Date: 17 October 2024  
Your Ref: EN070009  
Document Ref: 7.2

## THE H2TEESSIDE PROJECT

### REQUEST FOR PROPOSED CHANGES TO THE H2TEESSIDE DEVELOPMENT CONSENT ORDER ('THE H2TEESSIDE ORDER') APPLICATION

H2 Teesside  
 Viewpoint 5: South Gare Breakwater  
 Figure 16-7-2b Photomontage

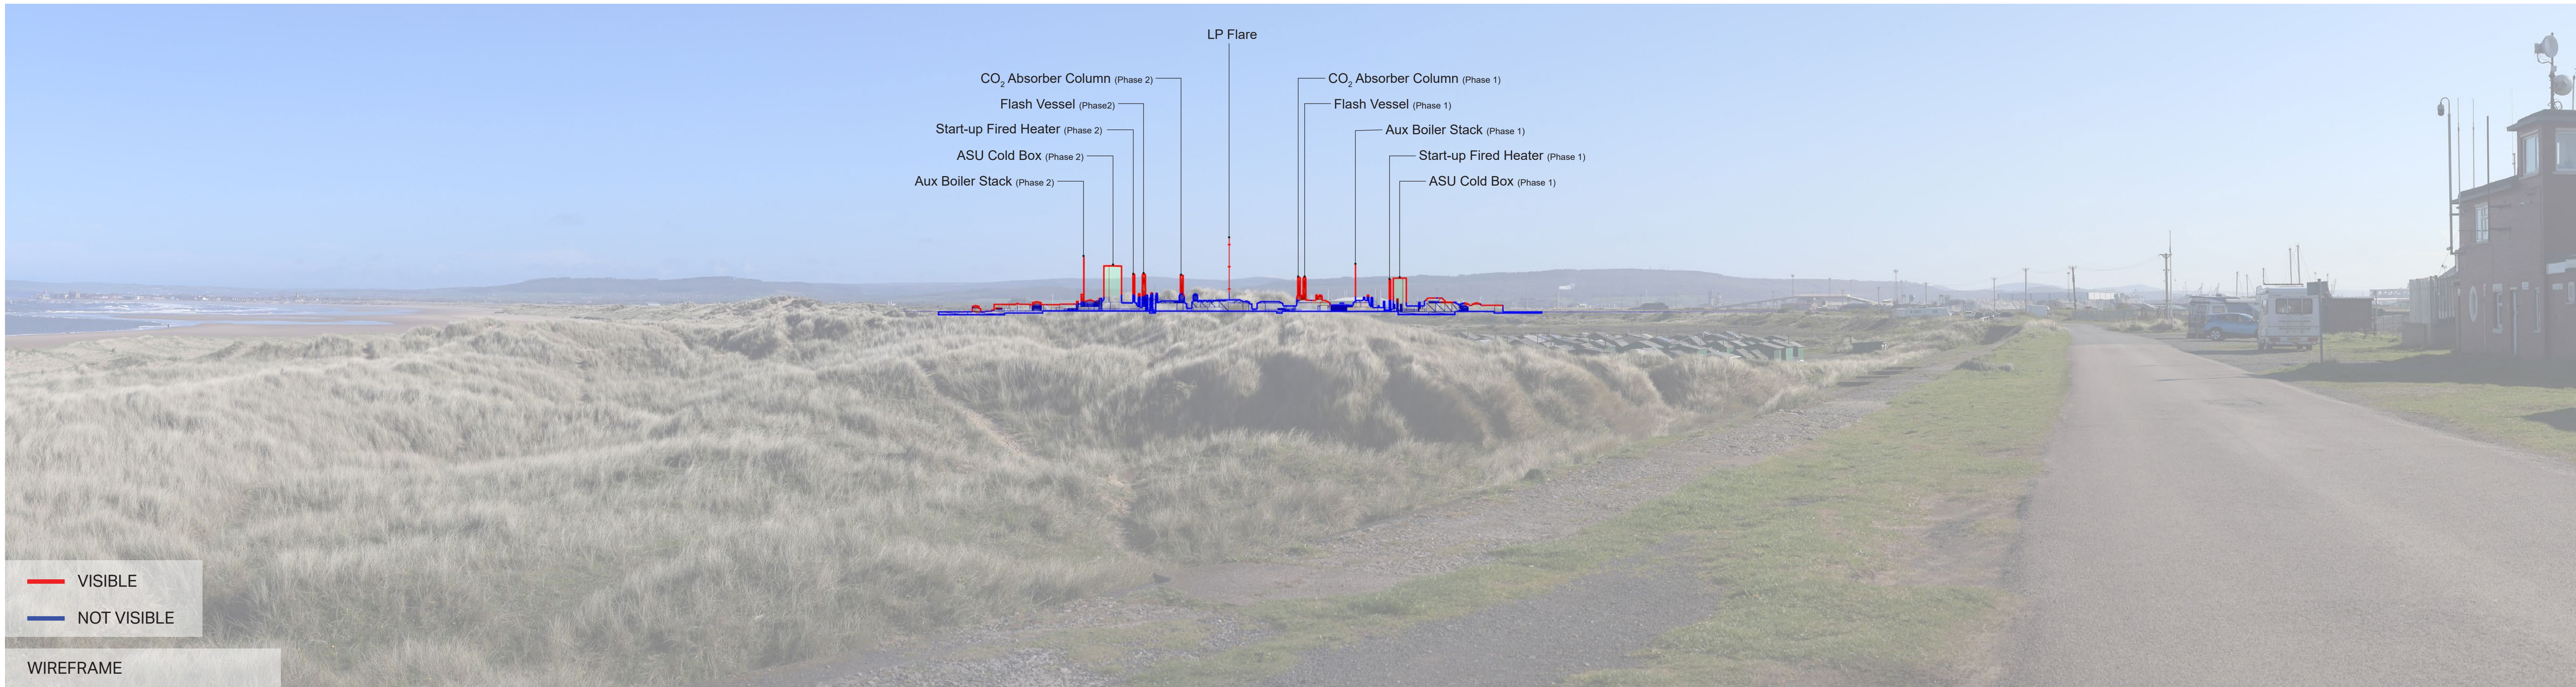
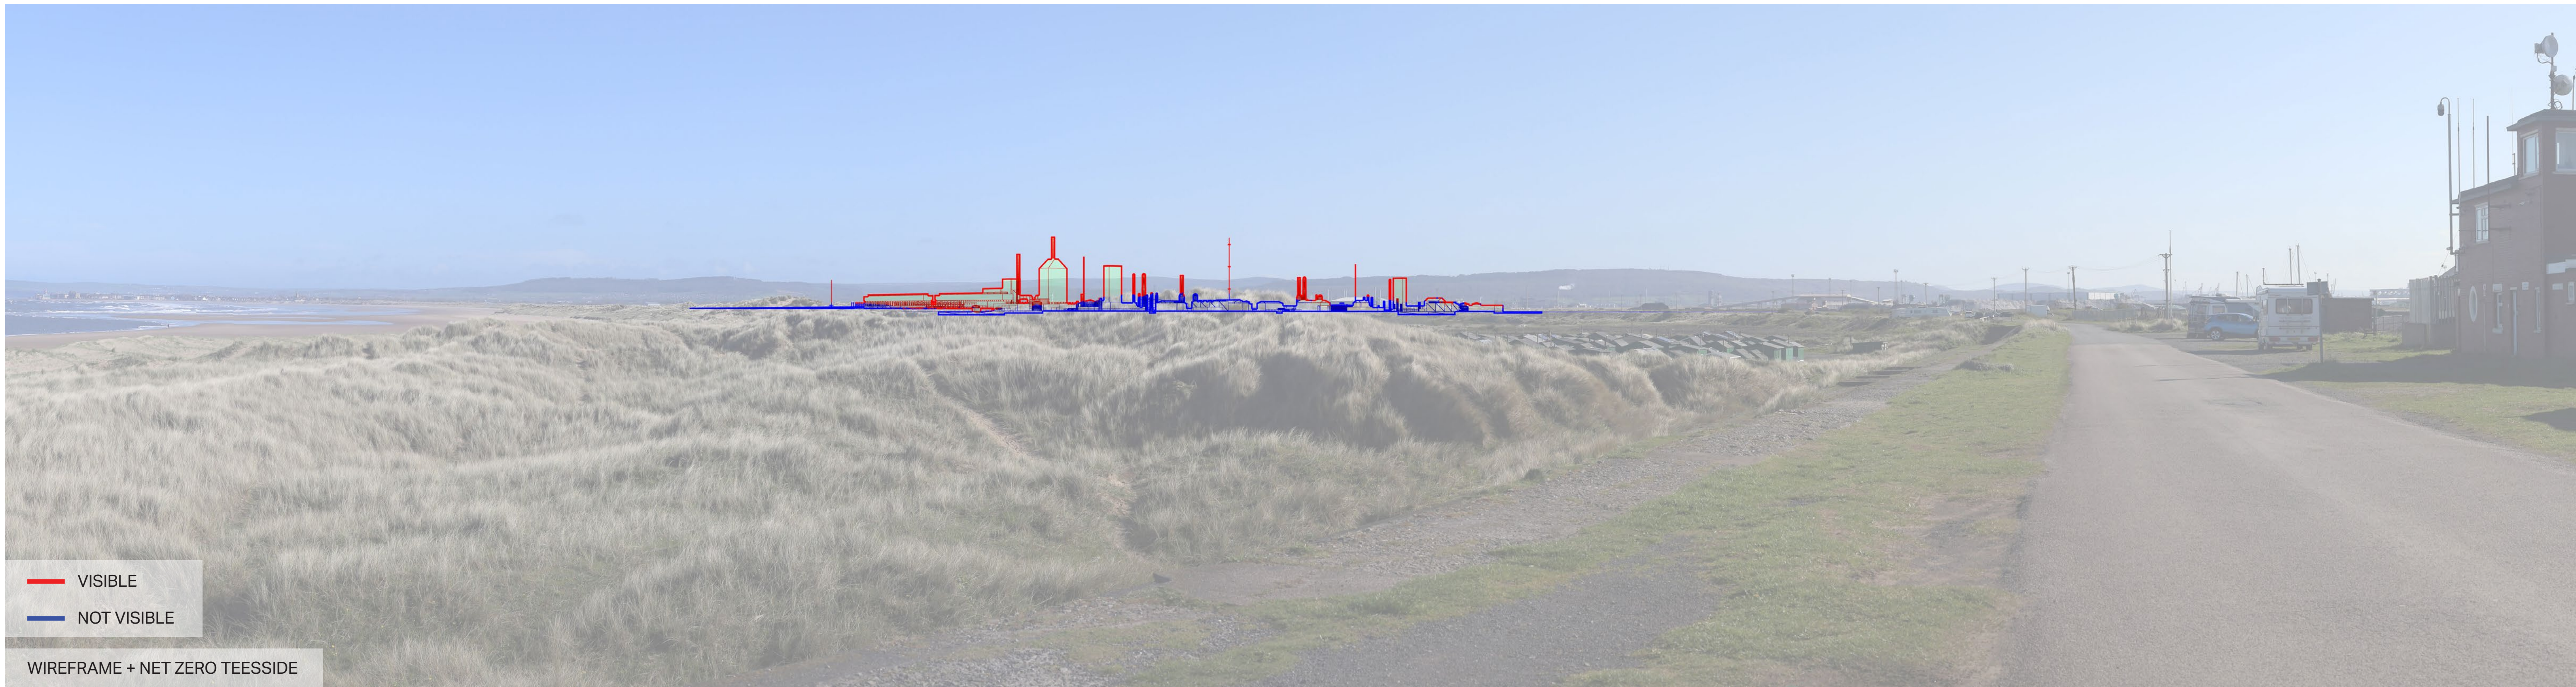
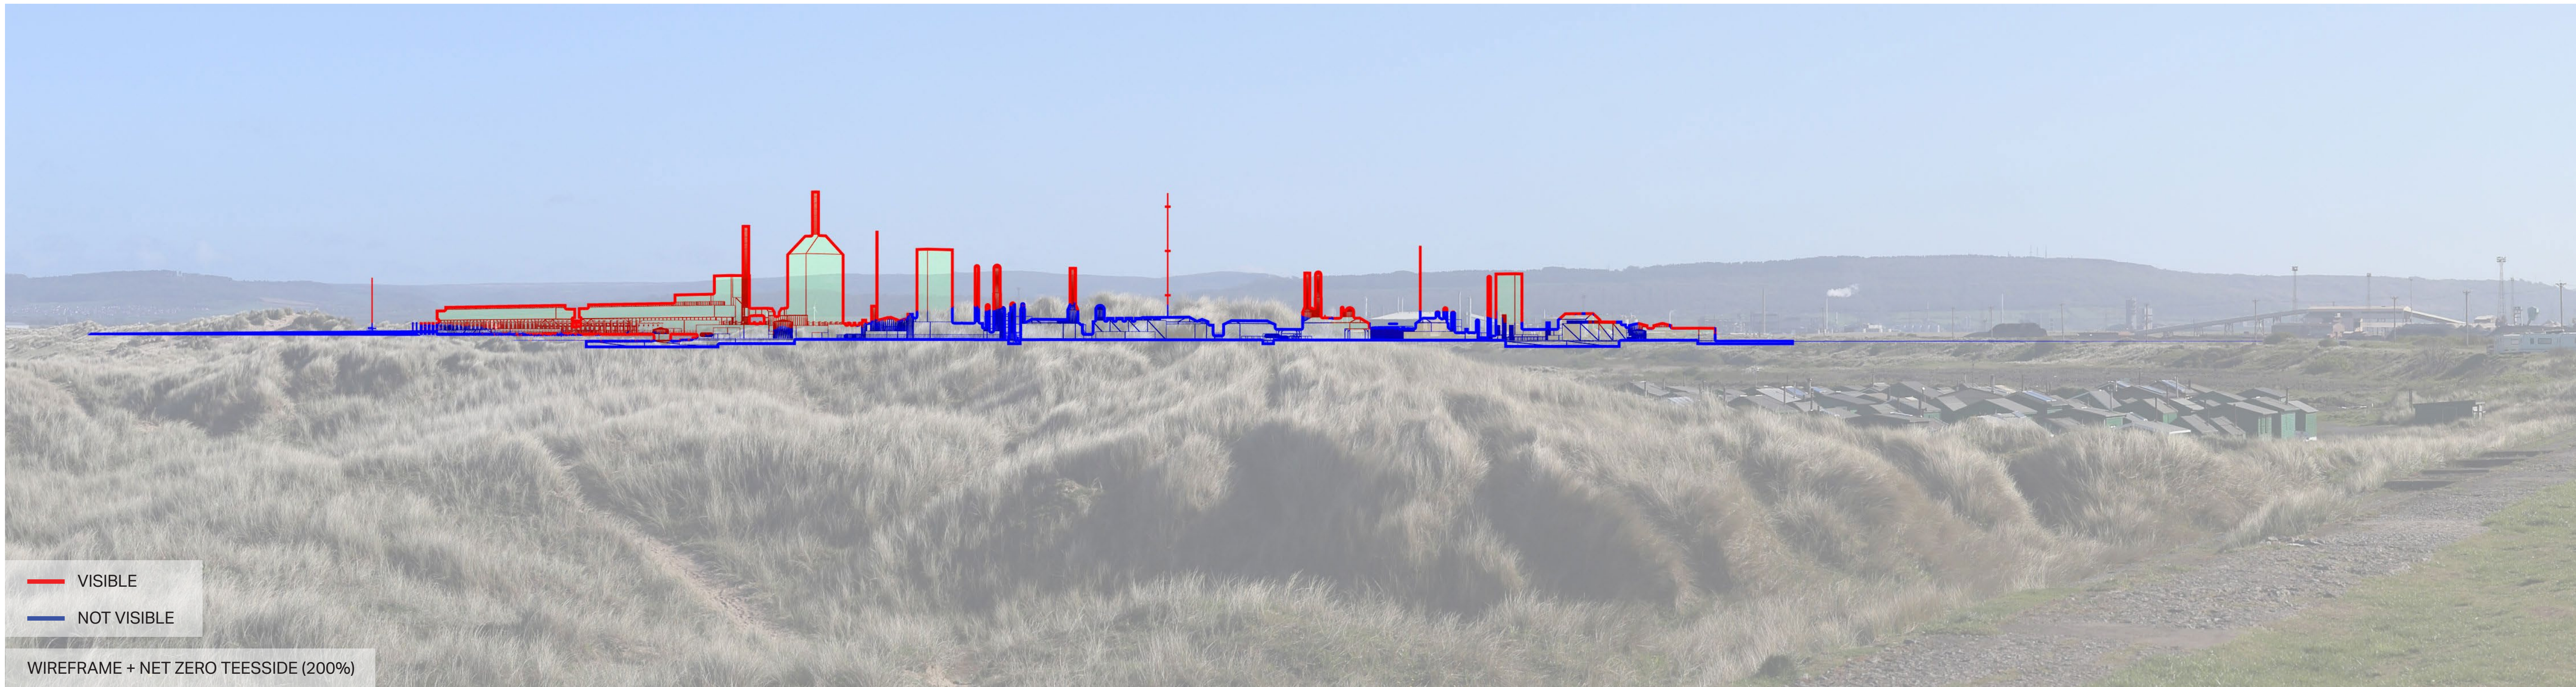
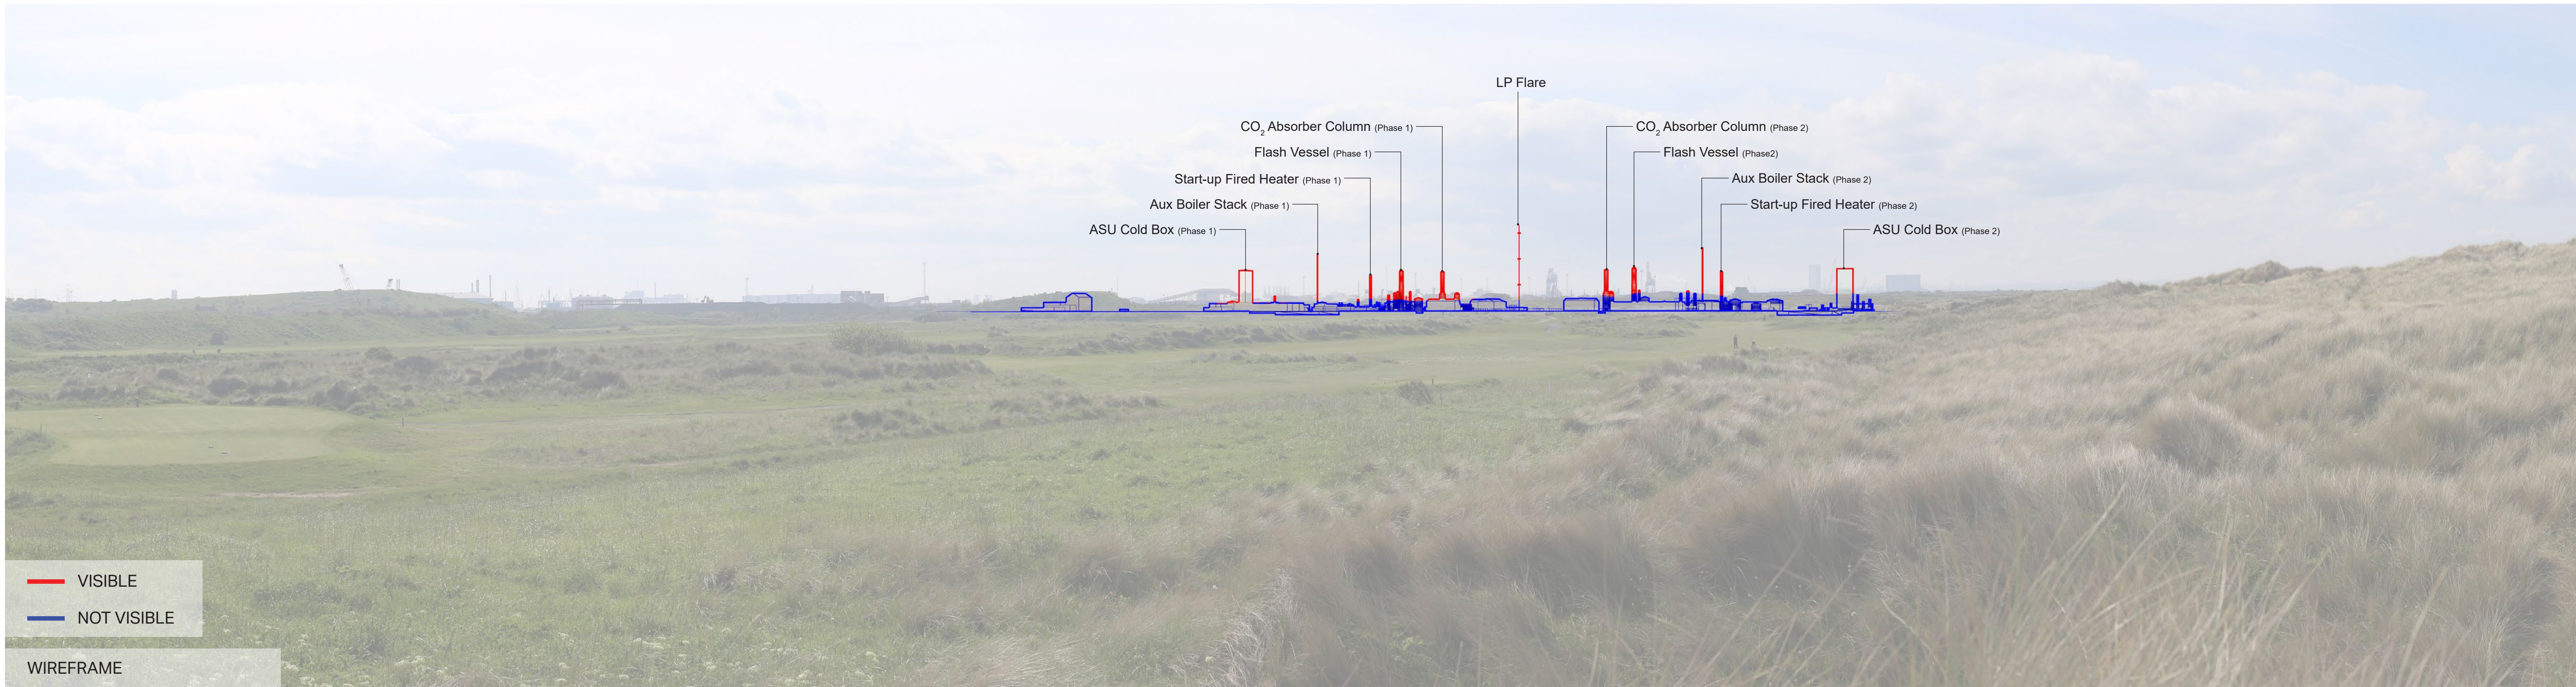
However, the Applicant has noticed an error with those photomontages and so is submitting updated revisions of these, which show one flare (i.e. the 'pre-changes' position). These have been submitted as an update to **Revision 2** [AS-030] – which we propose to call **Revision 3**.

The error in question was an incorrect representation of dimensions from the initial plot plan in relation to the flare. No changes to the dimensions are presented, only the interpretation of those numbers has been revised. Specifically, the flare was initially visualised inaccurately, suggesting a much more obtrusive structure. In reality, there is no wide platform below the flare. Instead, the flare consists of a 1 m diameter structure with a staircase running to the top.
